**RE: Winsome (f.k.a. McCune Ranch) Residential, RR-2.5 Rezone (P-18-006) – 1st Review Response**

This letter responds to your November 13, 2018 review letter relating to the above referenced project. Responses to review comments are shown in **RED** below.

ZONING PLAN

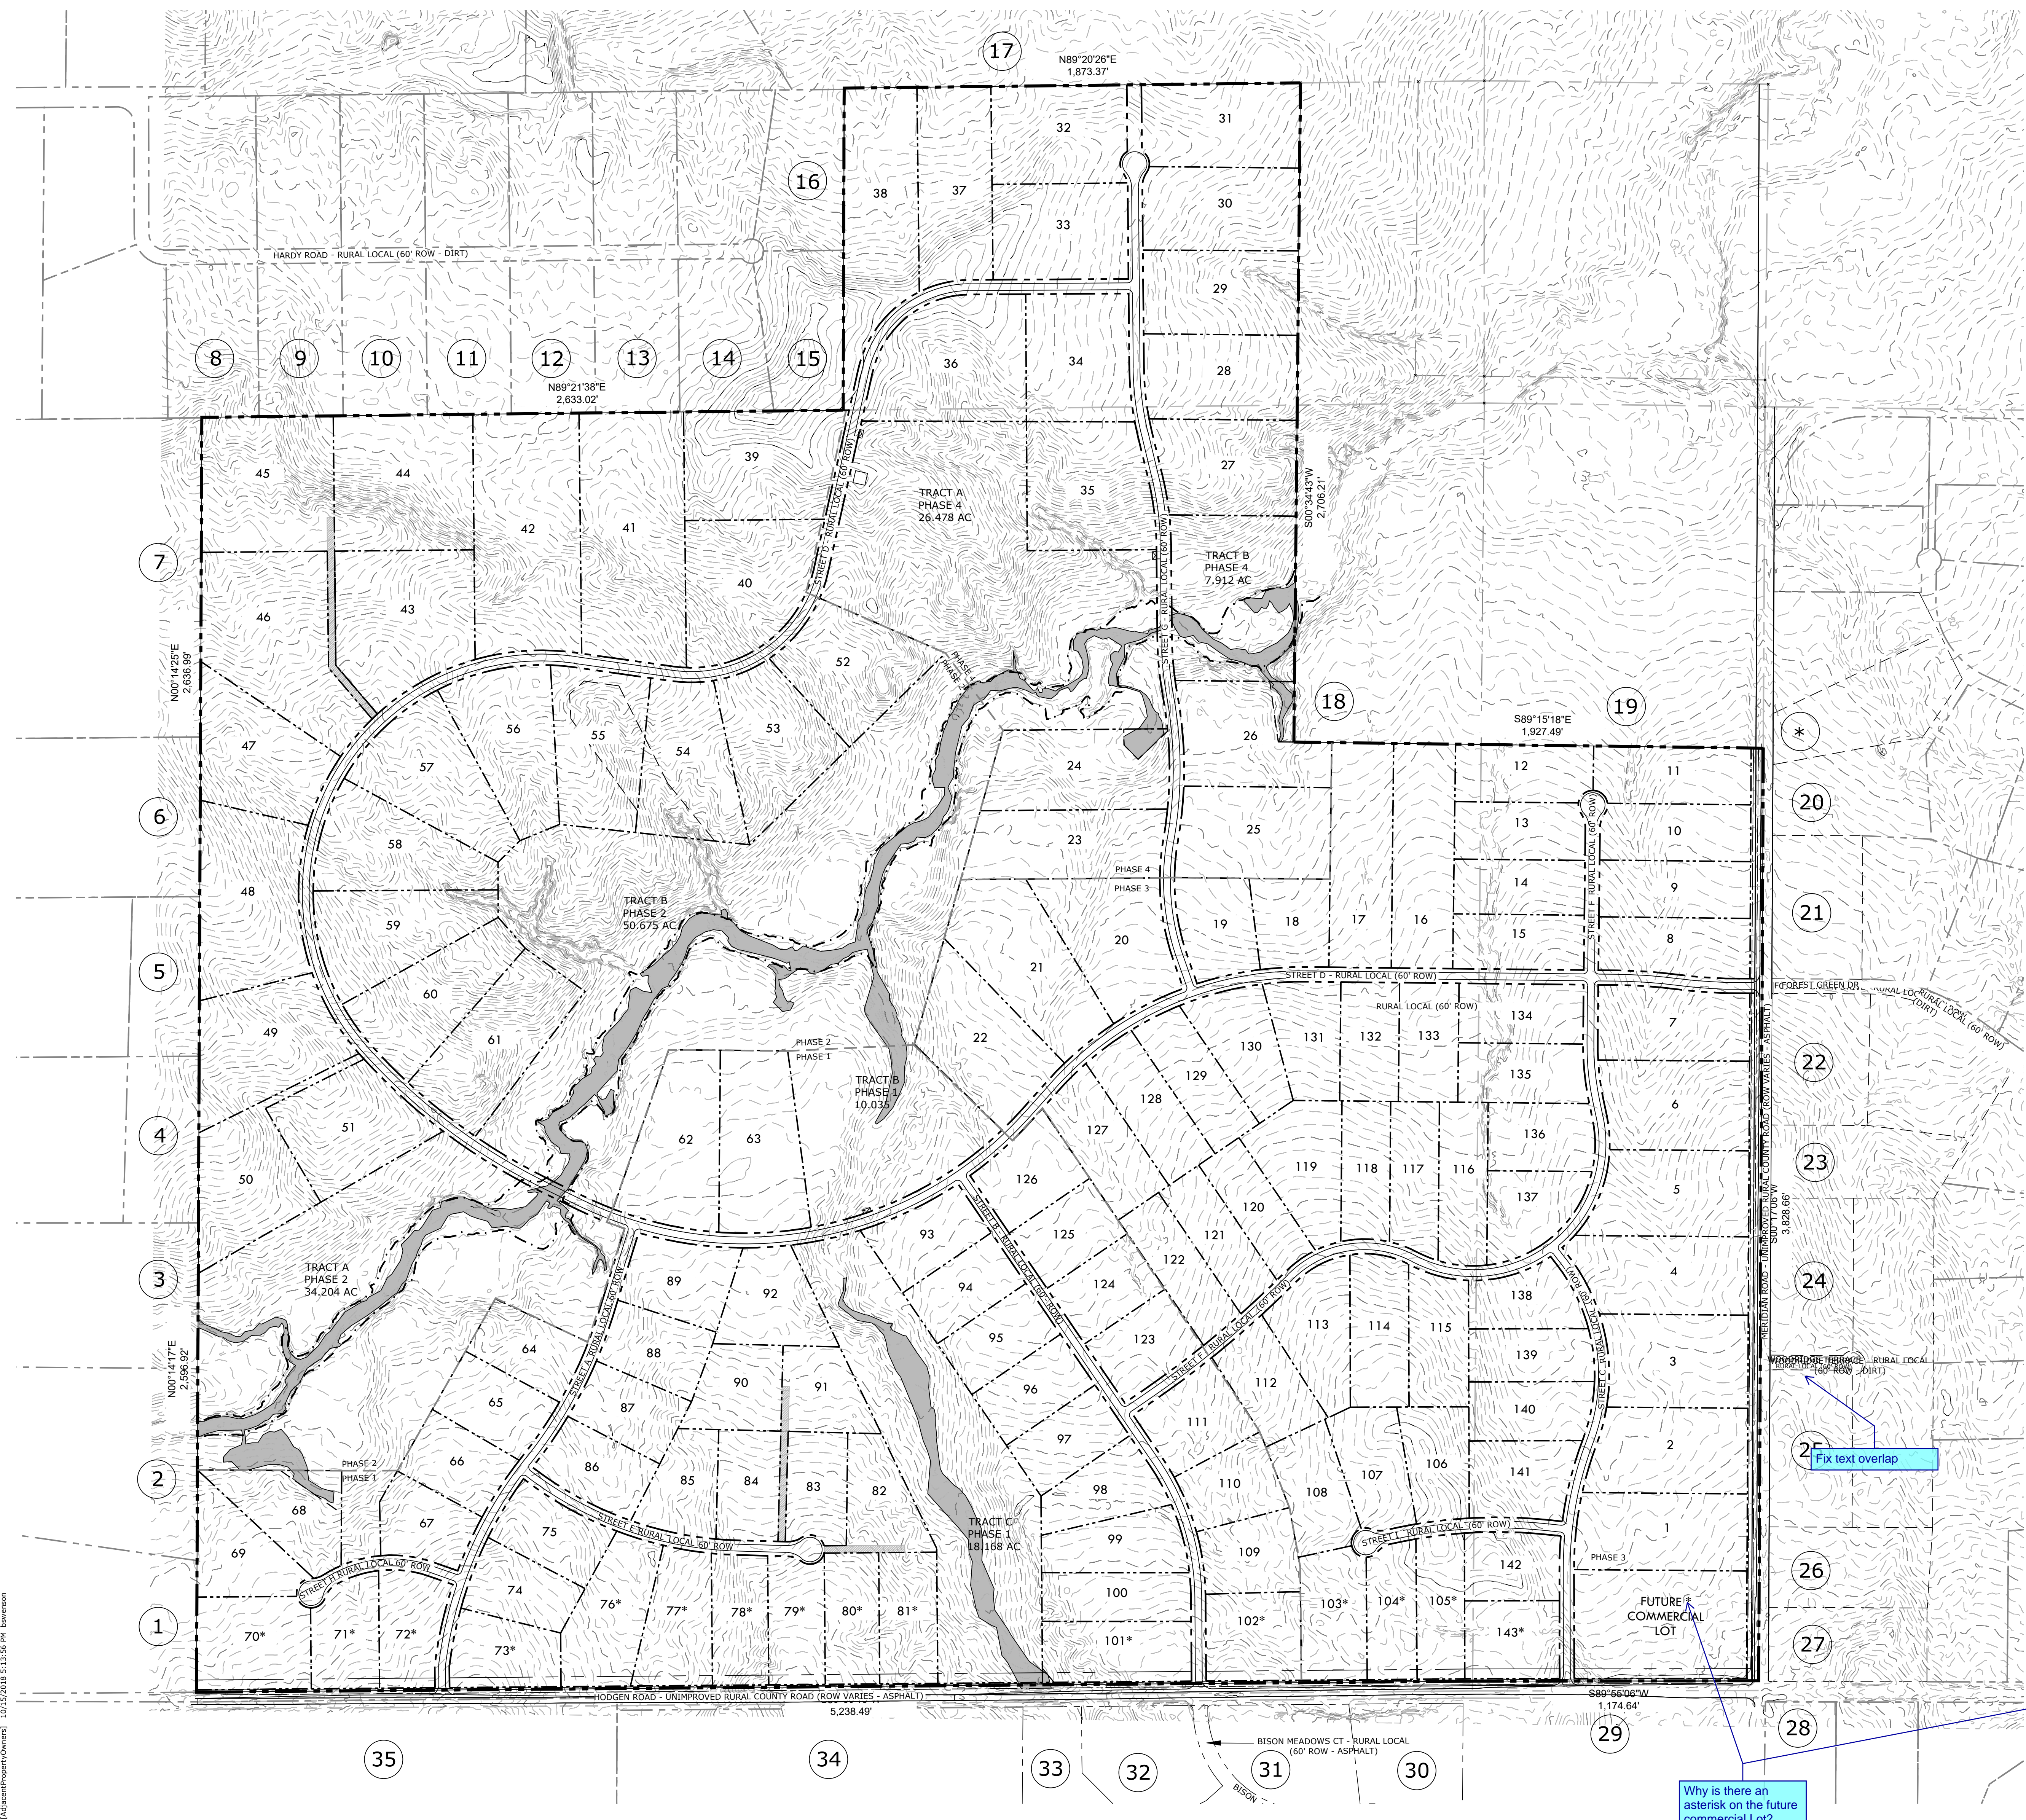
Review 1 comment to the zoning map will be uploaded by the project manager. **Received and addressed.**

1. Every residential lot near the development is zoned RR-5. This development proposal desires to designate approximately half of the land to RR-2.5 and add a commercial element directly across the road from a section that is designated A-35 and RR-5. Is that sound planning? Does it violate the norm by not having the lot transition occur within the development not at its periphery?

- a. Preliminary Plan drawings show the size of the lots. Why can't the developer place all the lots that are less than 5-acre internal to the development rather than have them abut neighboring lots of current RR-5 owners? Recommend that lots 68, 69, 71, and 72 located in the SW portion of the development, which are all smaller than 5 acres, be re-configured to larger lots. Likewise, recommend that lots 7-12 in the NE and lots 73-81 and 101-105 in the south be re-configured to at least 5 acre lots.

**Amendments have been made to the plan to provide 5-acre lots adjacent to the existing 5-acre lots on the eastern side of the development. In the SW corner there is a substantial electric easement that acts as a buffer to the larger lots to the west.**
